Your ref: 3/2025/0286
Our ref: 3/2025/0286/HDC/KW
Date: 02 May 2025

Location: Club Farm Worston BB7 1QA

Proposal: Variation of condition 1 (approved plans) on planning permission 3/2018/0678 (for new two storey extension to side and conversion of attached barn to existing residential dwelling; demolition of outbuildings and erection of garaging/office/store. Modification of access and landscaping works) to allow an alternative design of garage.

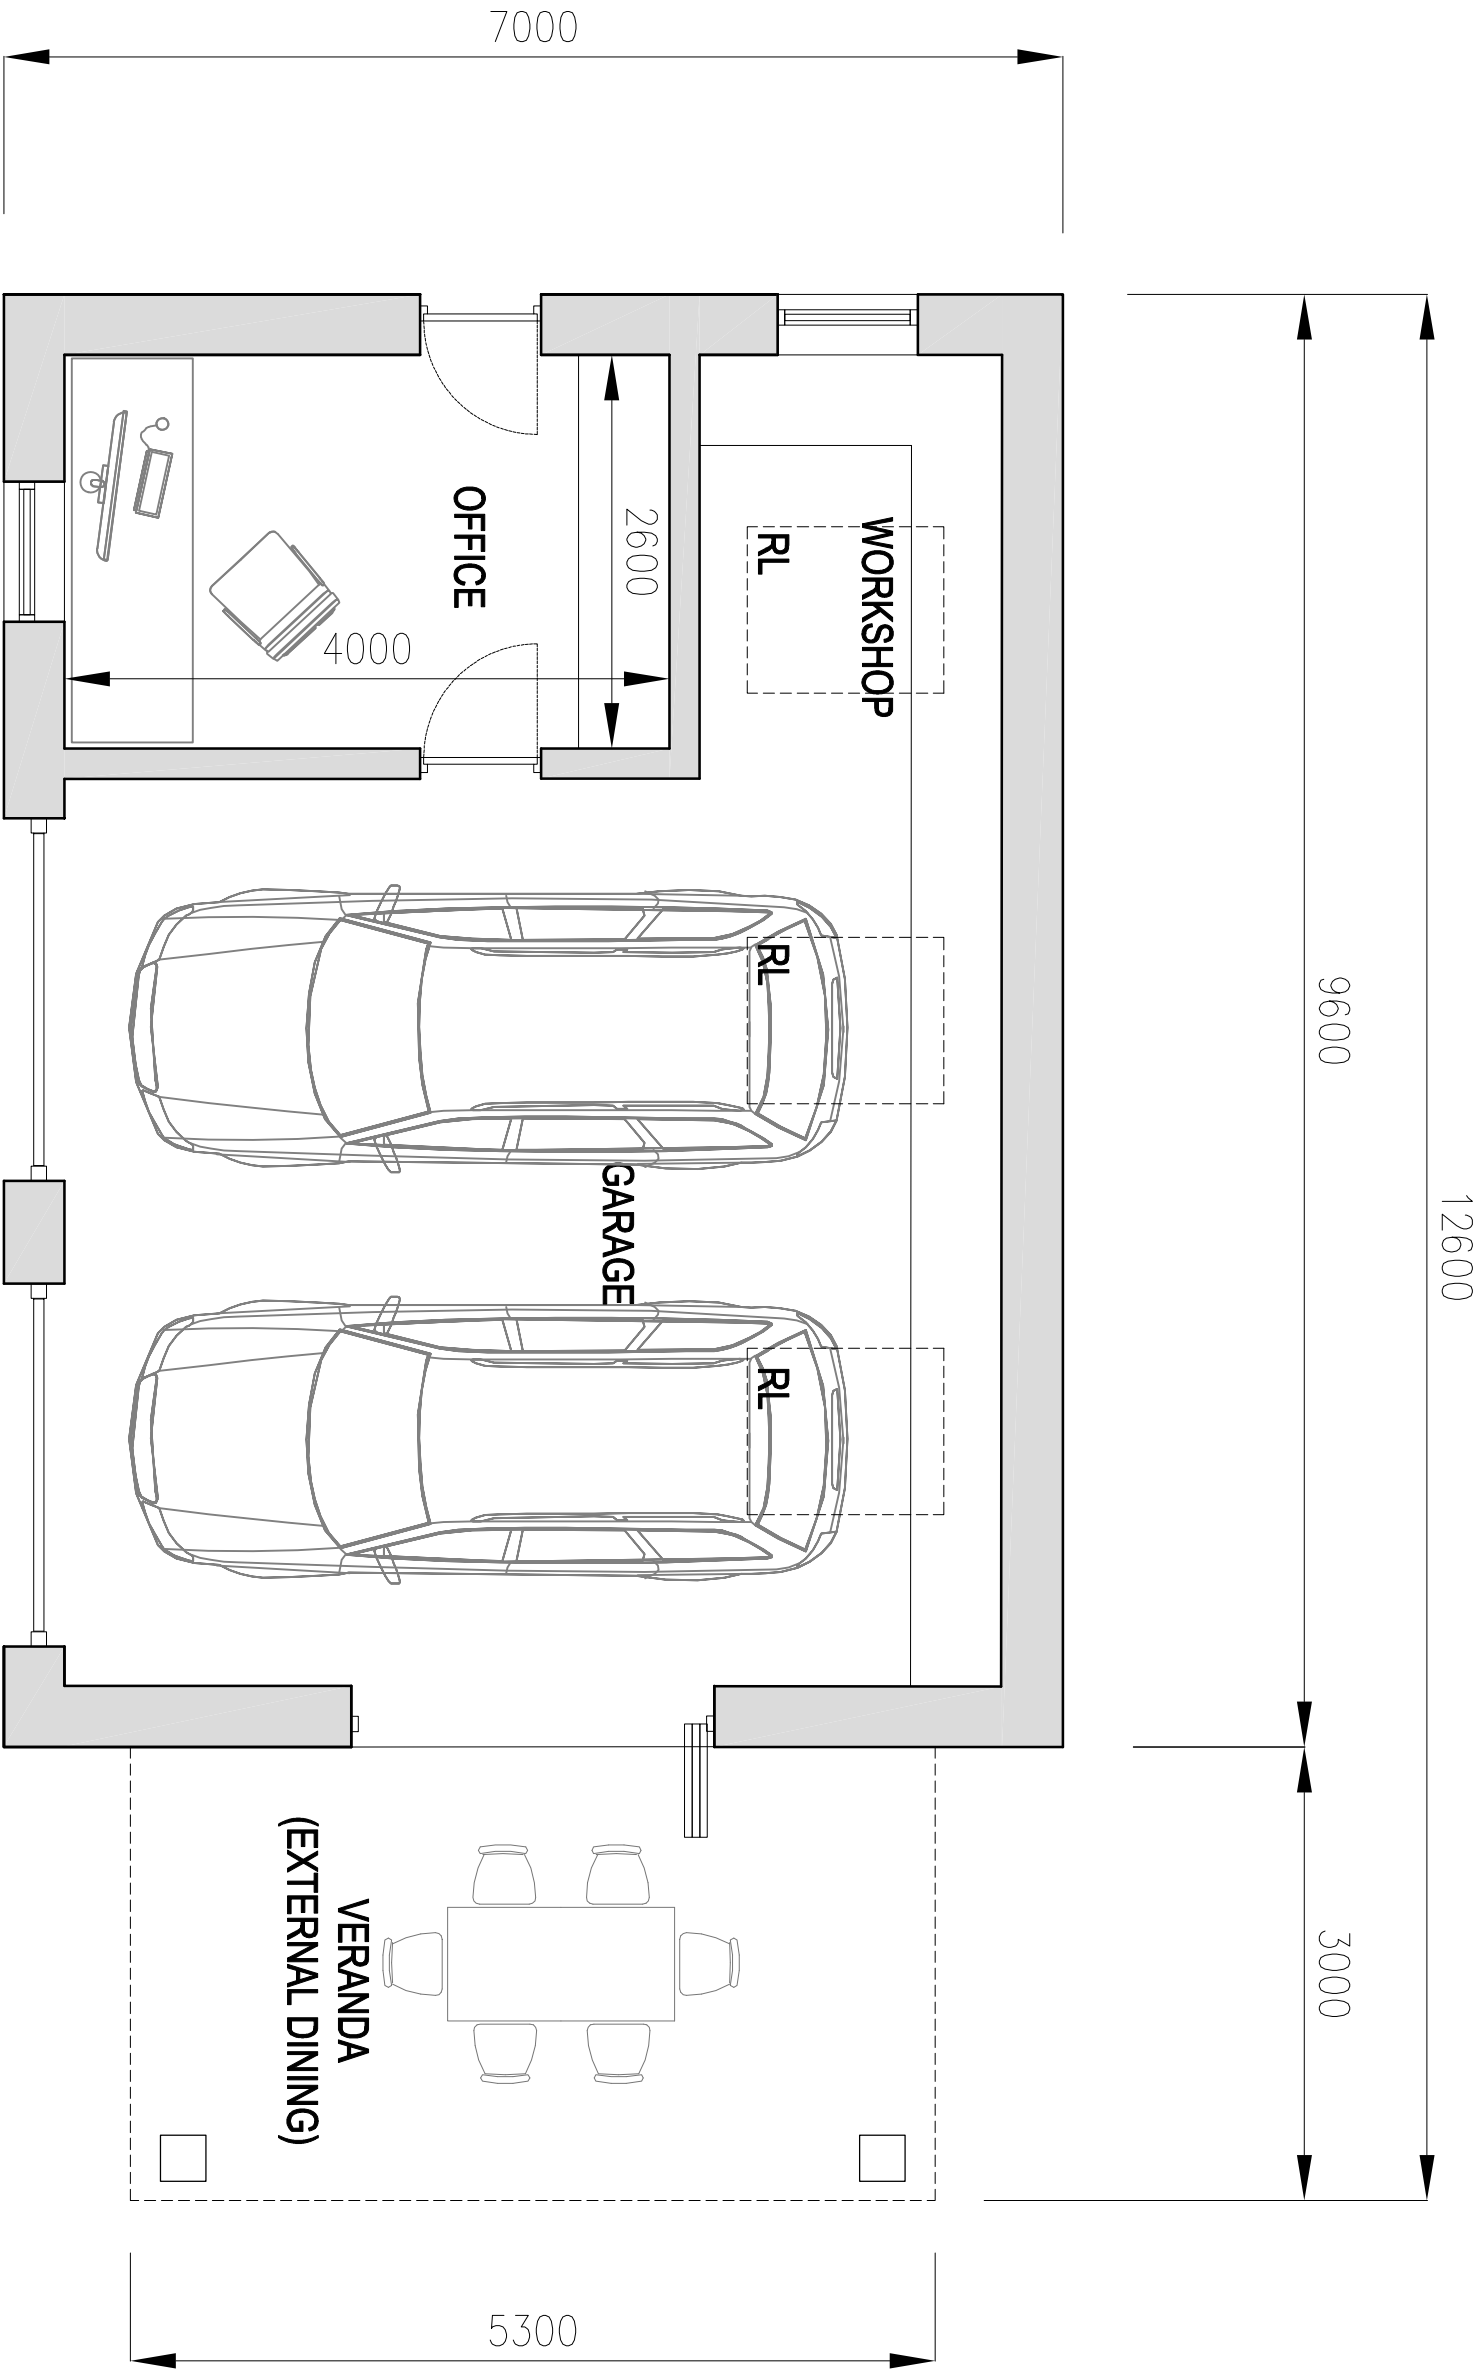
The LHA has reviewed the submitted documentation, including the previously agreed plans under application 3/2018/0678 and the amended garage meets the recommended minimum internal dimensions for a double garage which is 6m in length and 6m wide. As such the Highway Development Control Section of Lancashire County Council has no objections to the variation of conditions 1.
